SITE AT 31 ST EDMUNDS AVENUE, RUISLIP, MIDDLESEX HA4 7XW

PLANNING APPEAL ON BEHALF OF MR KAROL SIENIUC

LPA REF.: 58245/APP/2021/4066

**RESPONSE TO
LONDON BOROUGH OF HILLINGDON'S APPEAL STATEMENT**

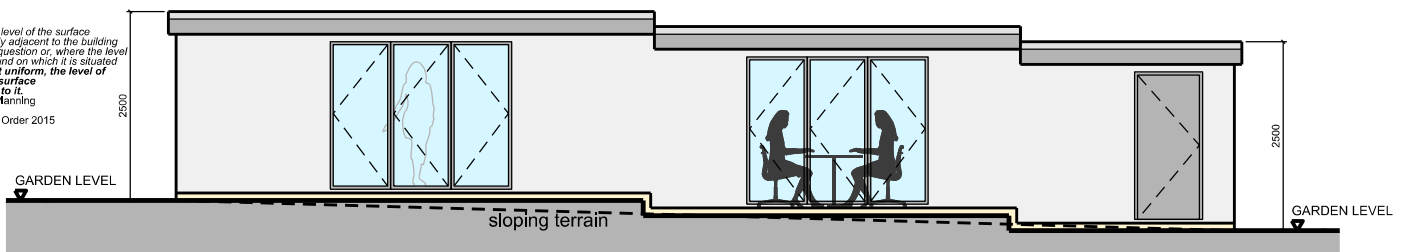
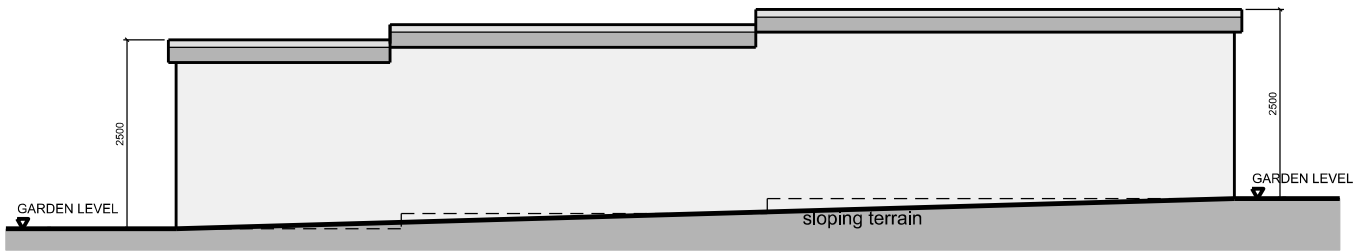
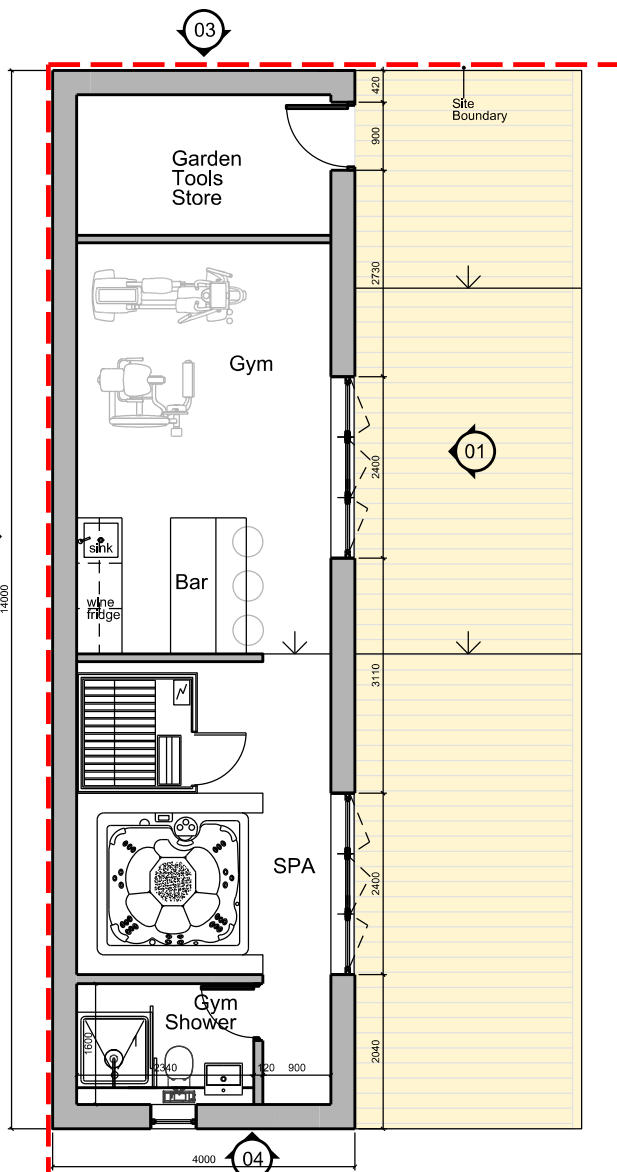
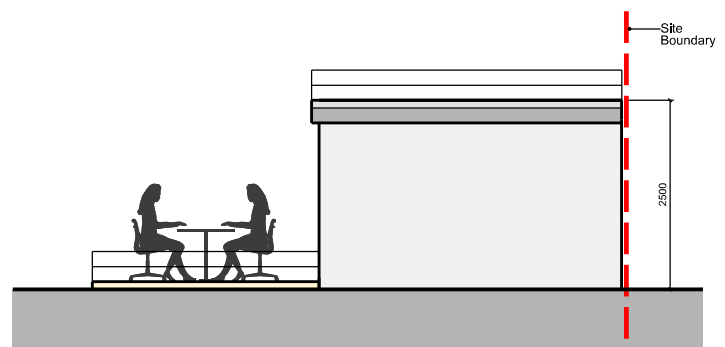
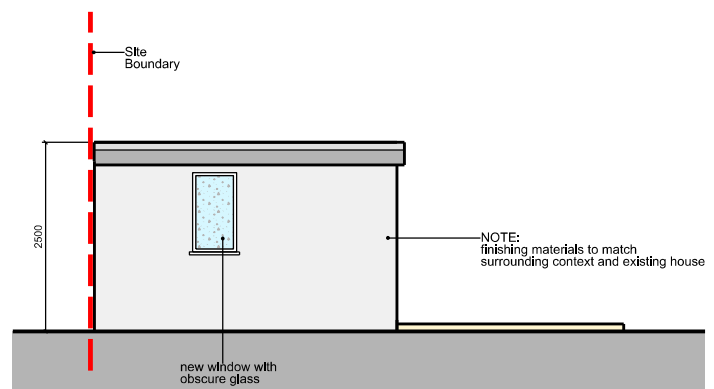
2.10 The Council dispute the measurement taken on site of 2.5 meters. It is clear from the photographs that I submitted that there is an area of concrete adjacent to the drainage gully that is 2.5 meters down from the eaves. This concrete level is repeated on the other side of the gate and it is clear that this is the natural ground level of the adjoining garden. Unfortunately I was not able to take a photograph on this side of our client's outbuilding as no access was available to the adjoining garden. Nevertheless, I would suggest that a discrepancy of 30 mm is in itself de minimis and I will leave it to the Inspector to make his own judgments on this.
